The **Arun Conservation Area Advisory Panel** wish the following comments to be taken into consideration in the determination of the applications:

Y/48/25/PL - Church Farm House, Church Road, Yapton

Drawing Title:
Site Plan

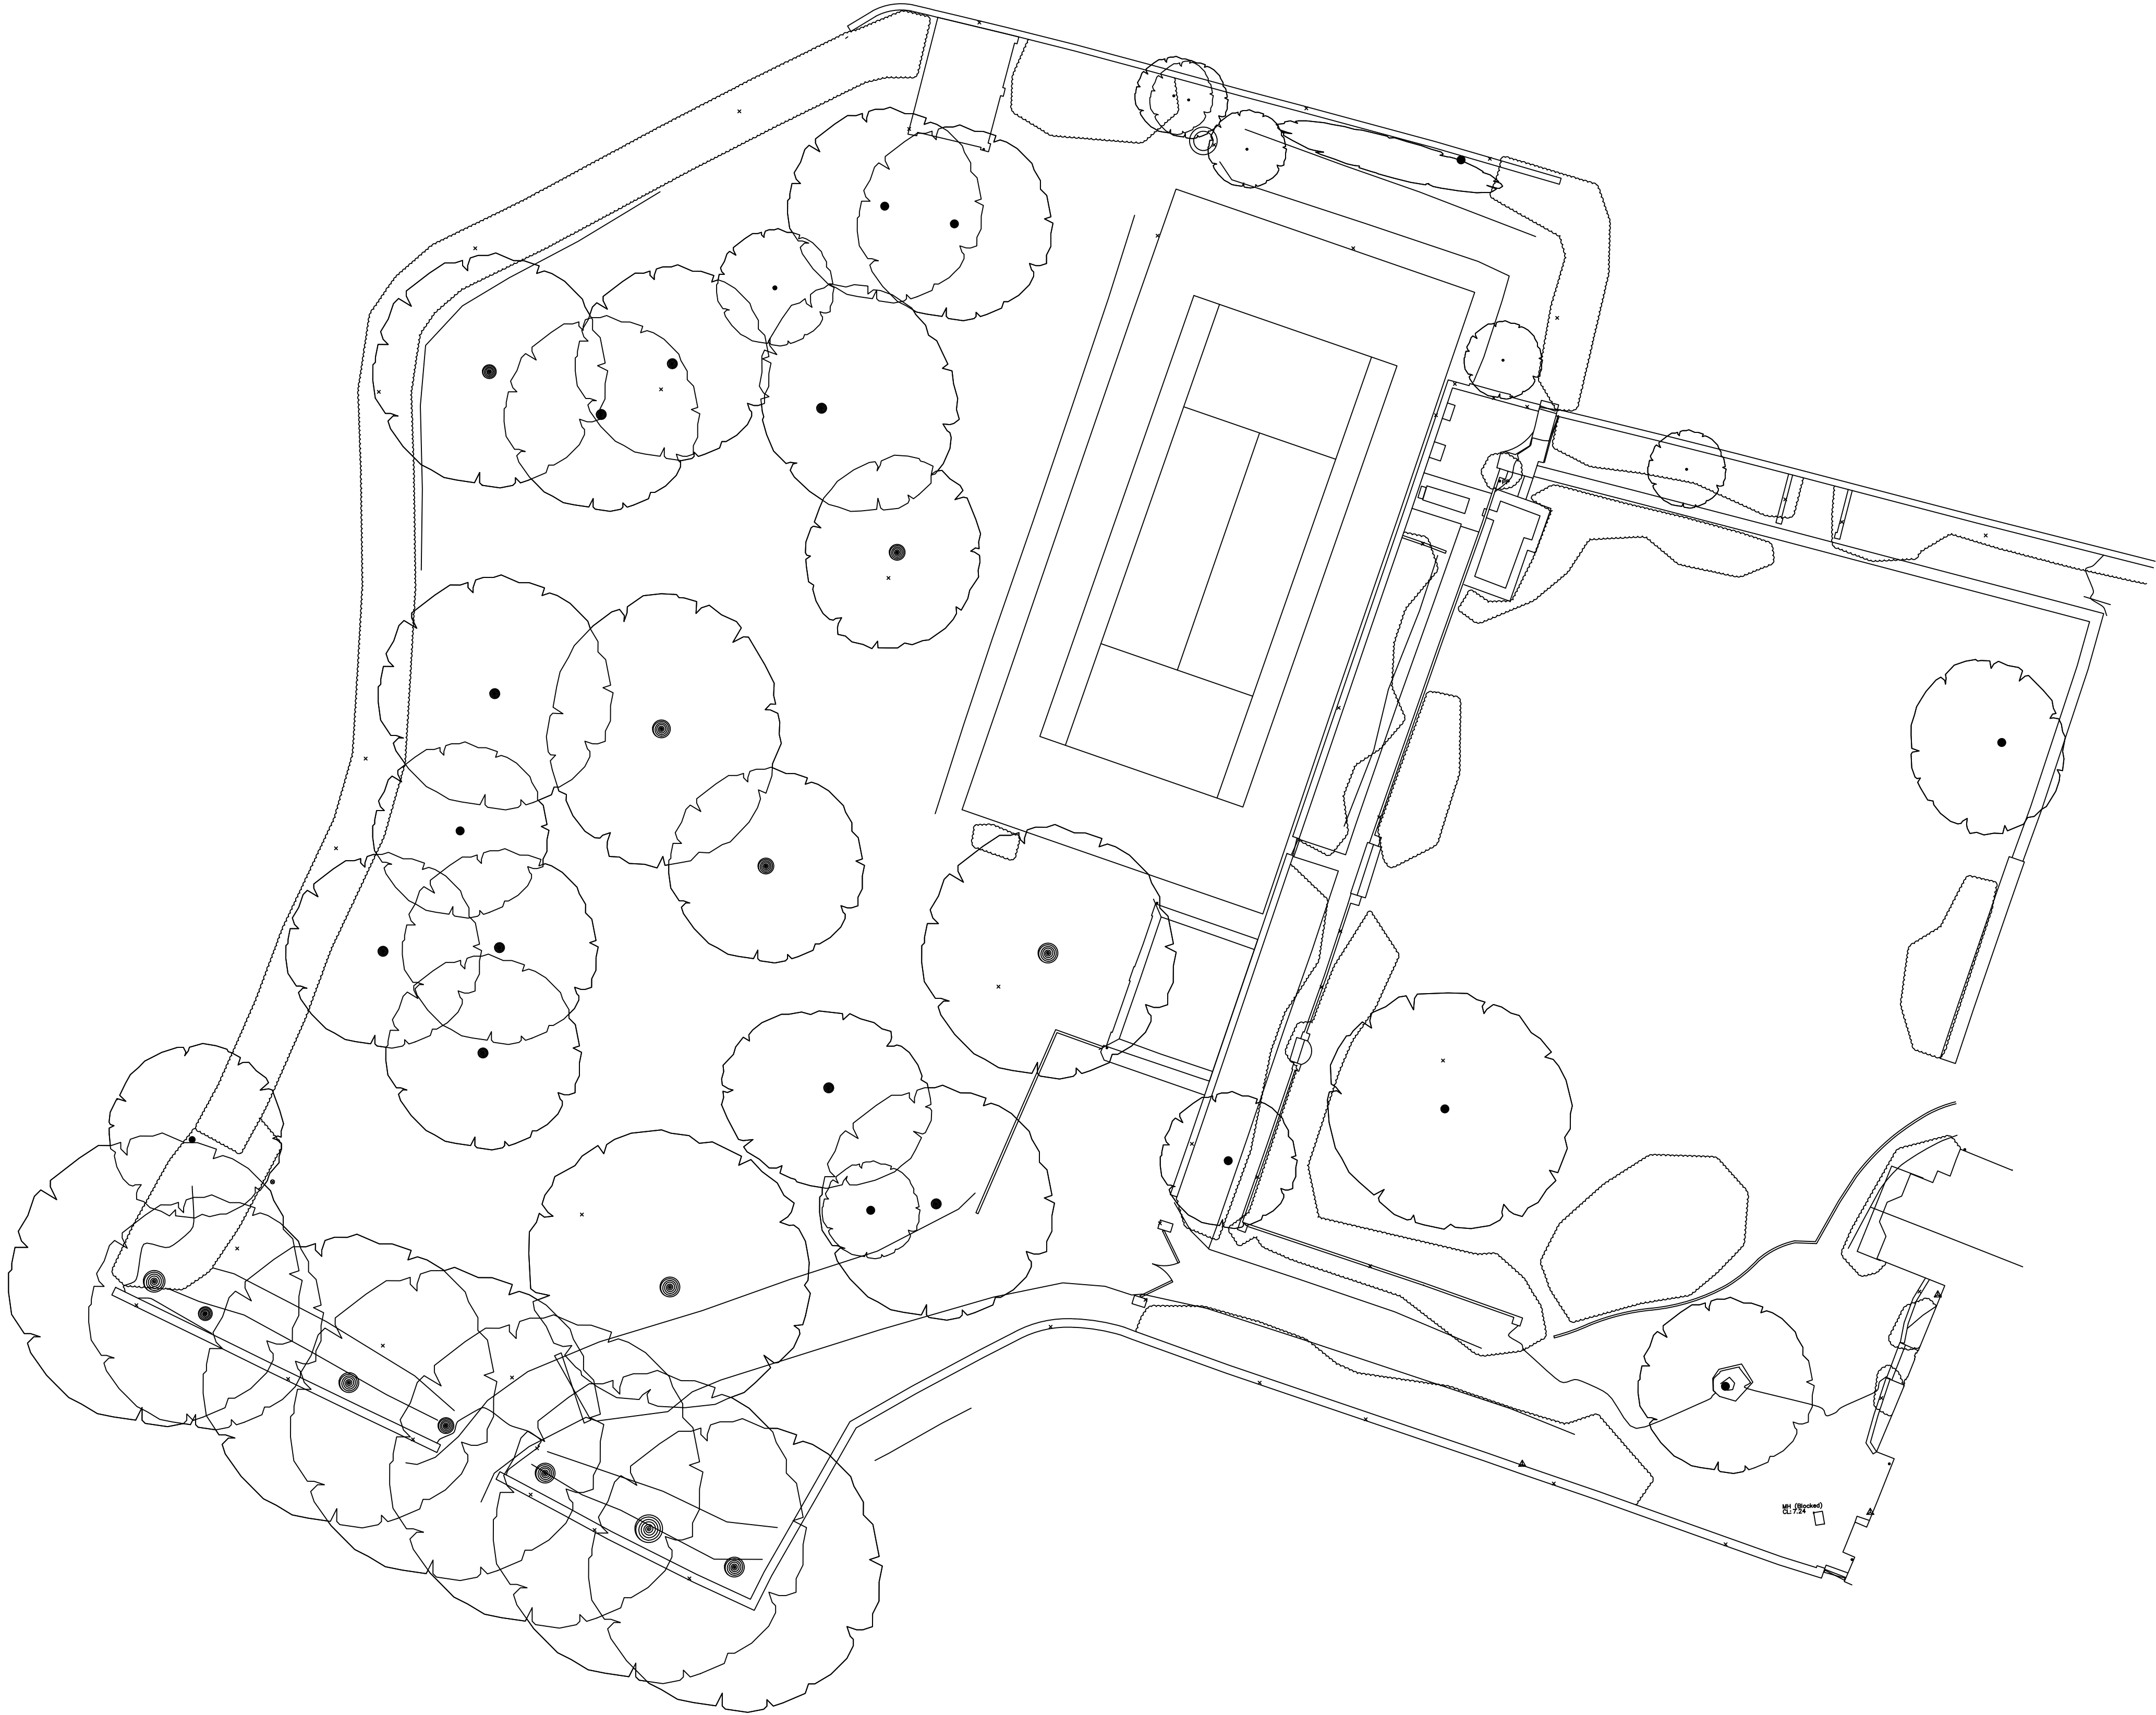
The Panel considered that, from the plans, there is the basis for a high quality design but that needs to be proven as part of the application with, for instance, precise large scale drawings of fenestration, doorways, fascia's, rainwater disposal details etc as well as external wall treatment. A roof plan should also be required since it is not clear from the plans what is intended to be glazed or solid wall. Again, given the semi-rural character of the locality and the designated heritage asset context a proposed landscaping plan should be submitted as part of the application. The Panel considered that it would be important to soften the appearance of the new building as viewed from the roadway by providing additional tree planting of an appropriate species. The red edging may need to be moved further south to embody such new planting.

On a point of detail the Panel wondered if the existing access way should be included within the red edging and also whether adequate parking space is proposed to be provided for the existing property. Note: Cllr Victoria Newman declared an interest in the application, left the room, and thereby took no part in the Panel's consideration of the application.
